Application No: FP/175/20/HH
Site Address: 23 Thirlmere Way Felpham PO22 8NQ
Description of works: Single storey side & two-storey rear extension.

Thank you for your internet representation made on 9th October 2020 which has been recorded as an objection with the comments as follows:

Drawing Title:
PROPOSED PLANS AND ELEVATIONS

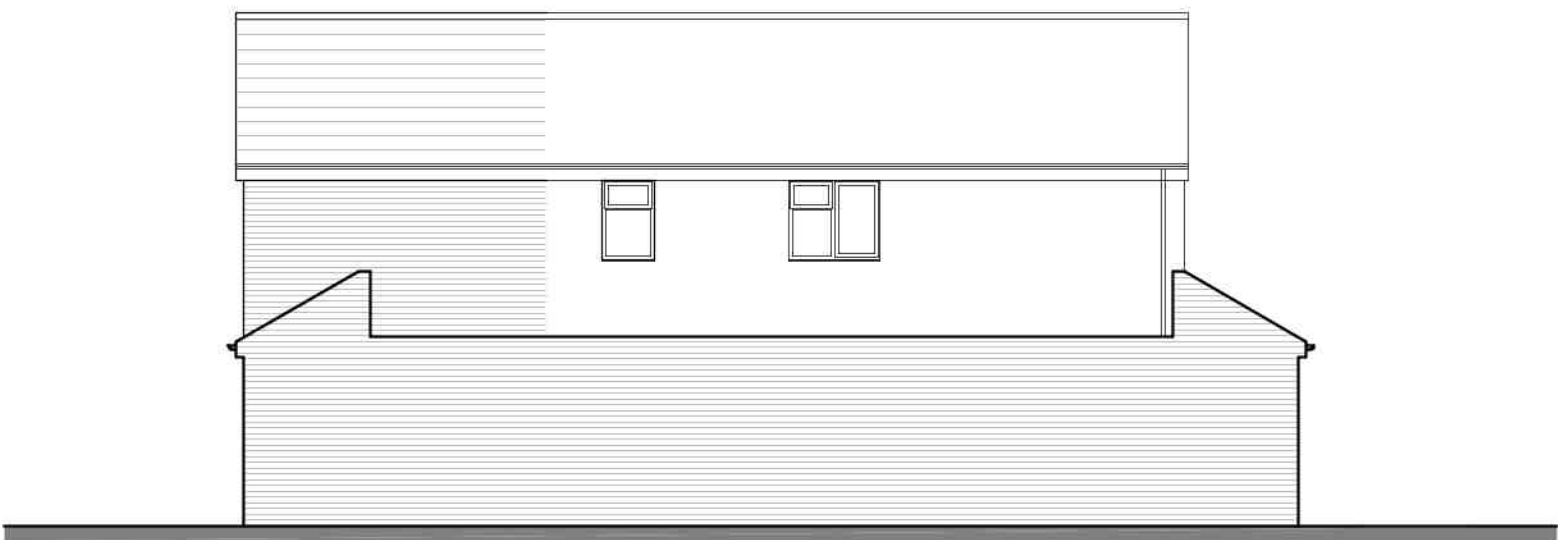
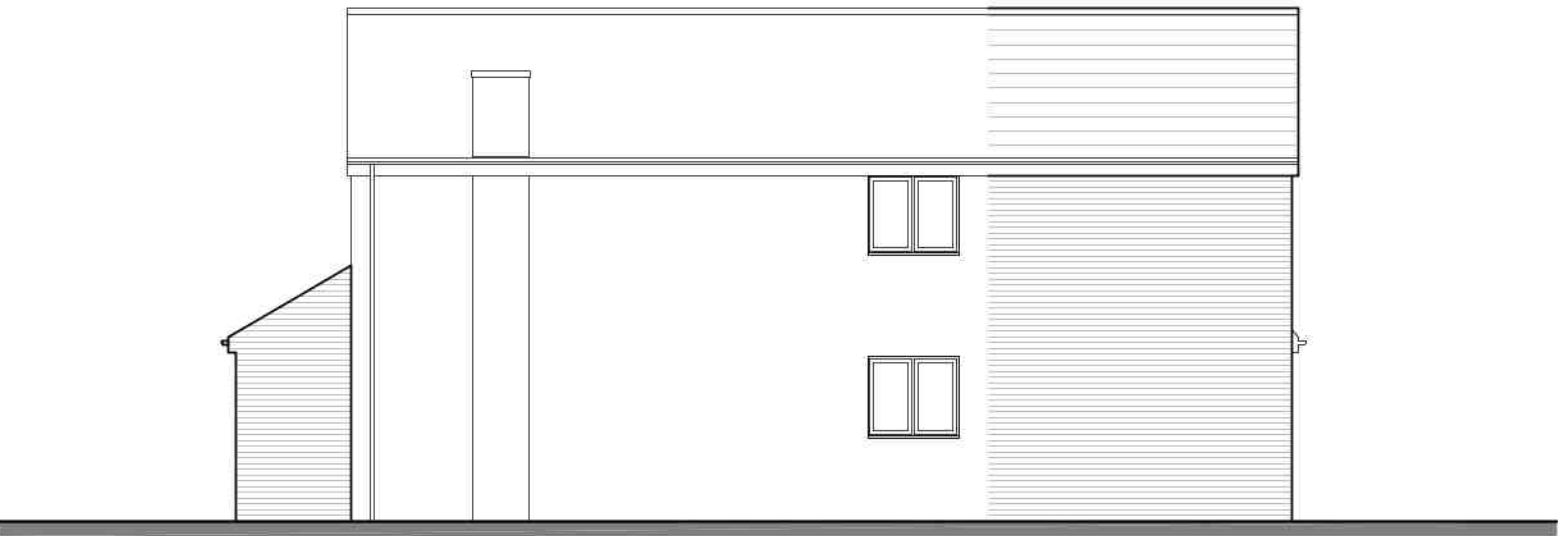
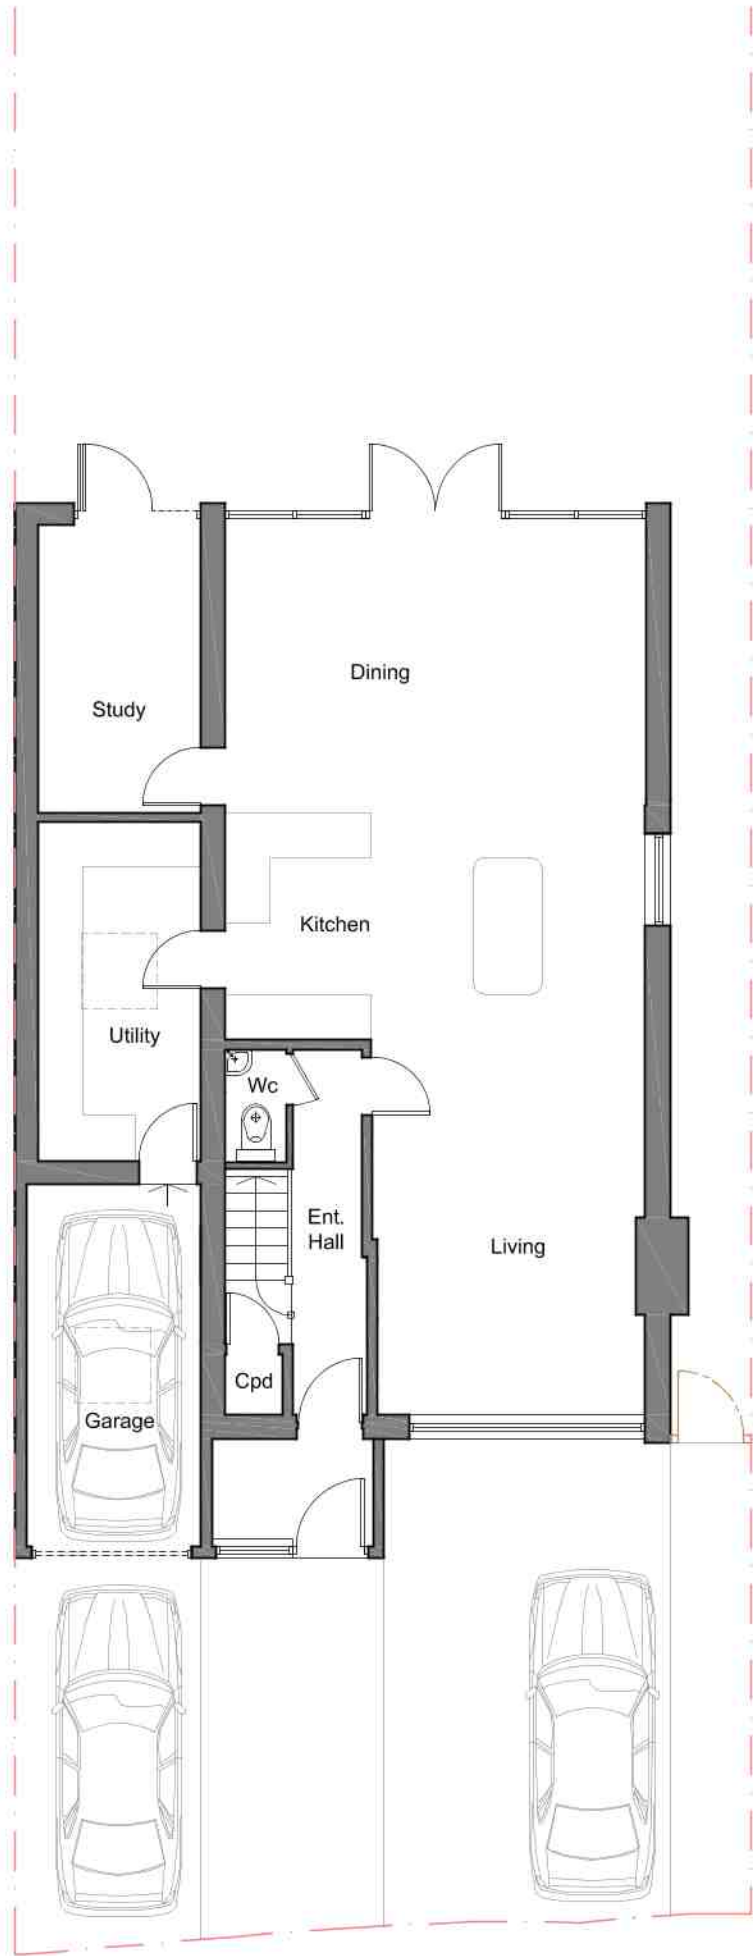
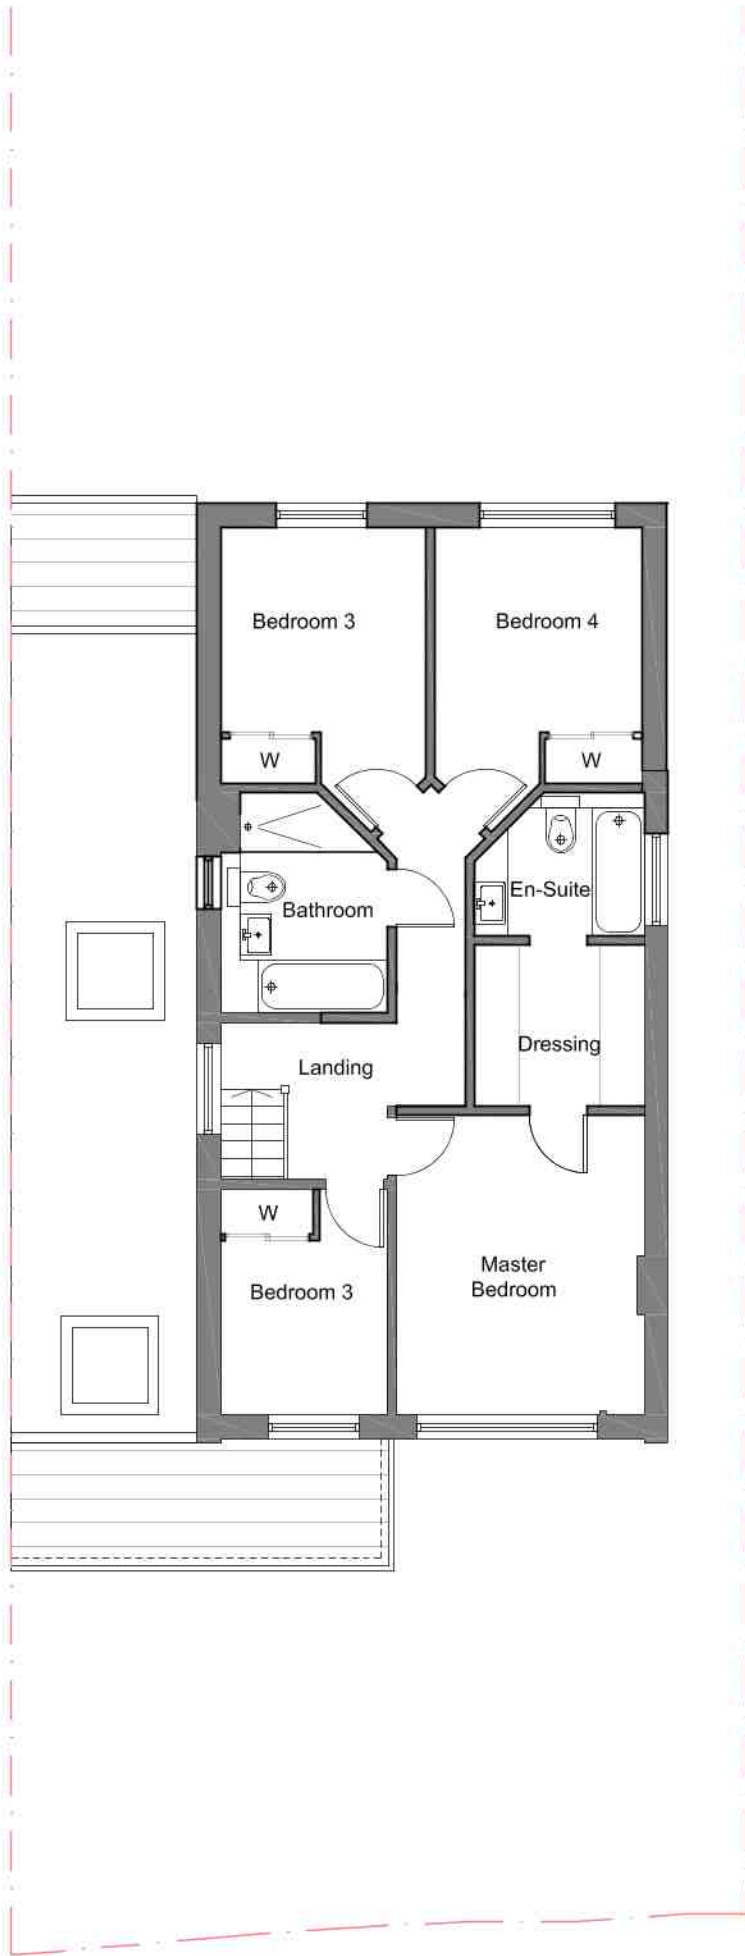
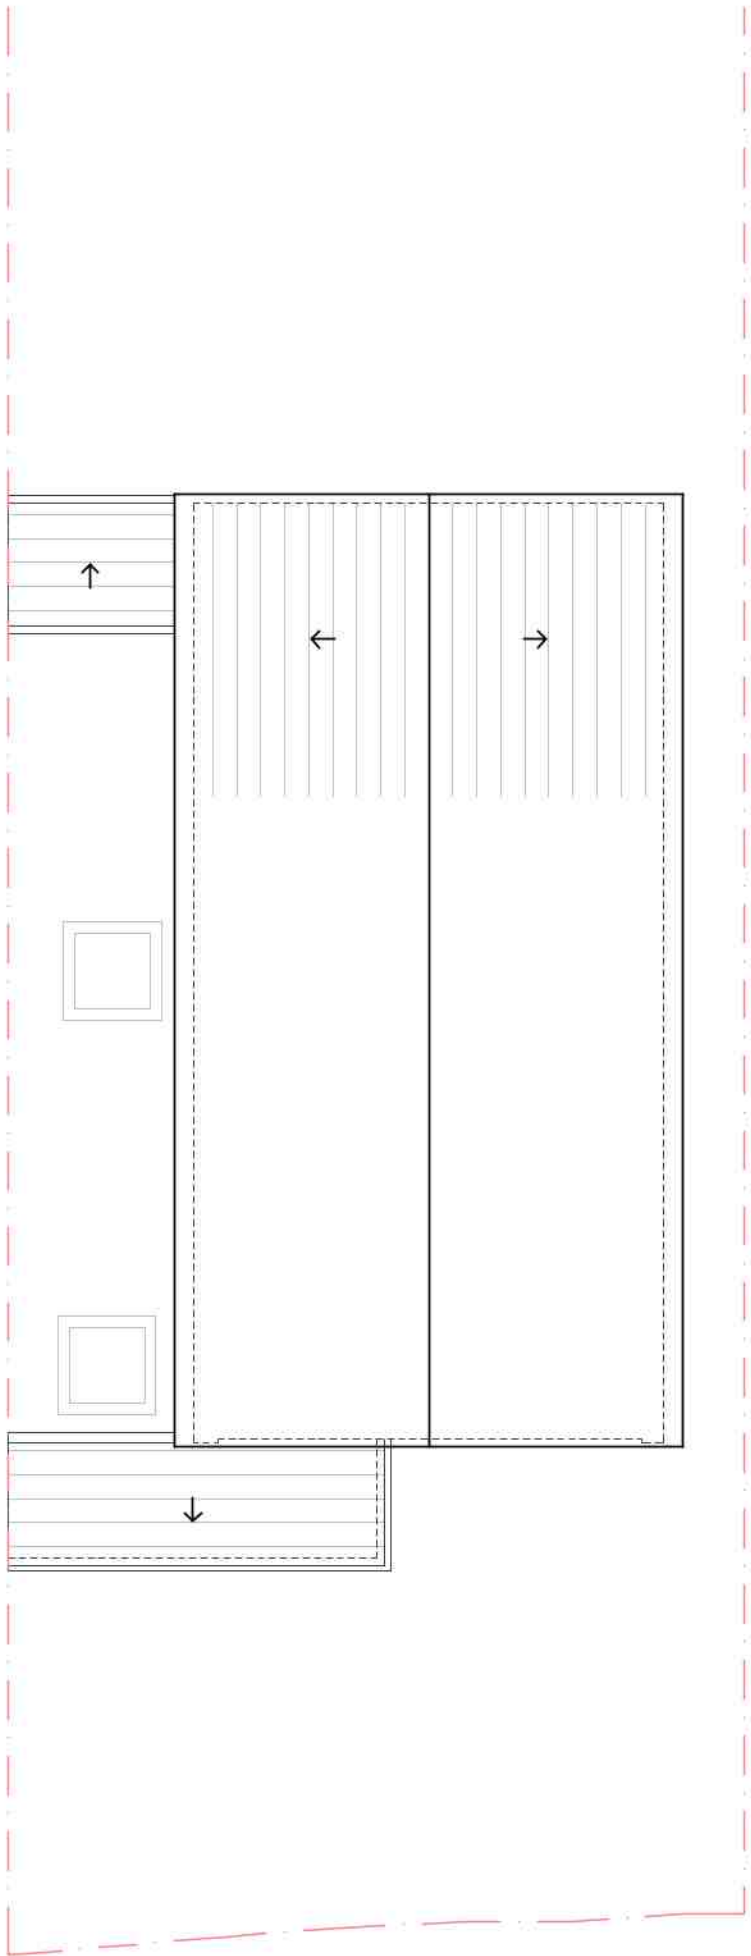
The double height extension to the rear of the property if permitted would completely overshadow the rear garden of our property. This will in effect mean the garden and rear of our house will be in shadow for the majority of the day. I also object to the addition of the two windows on the northerly facing wall. These windows will look directly into our property and cause a serious impingement upon our privacy. This was a plain brick wall and the fact that we were not overlooked was a major consideration when purchasing the property, some thirty five years ago. I also believe that the proposed development of this property will have a detrimental on the value of mine and surrounding properties.
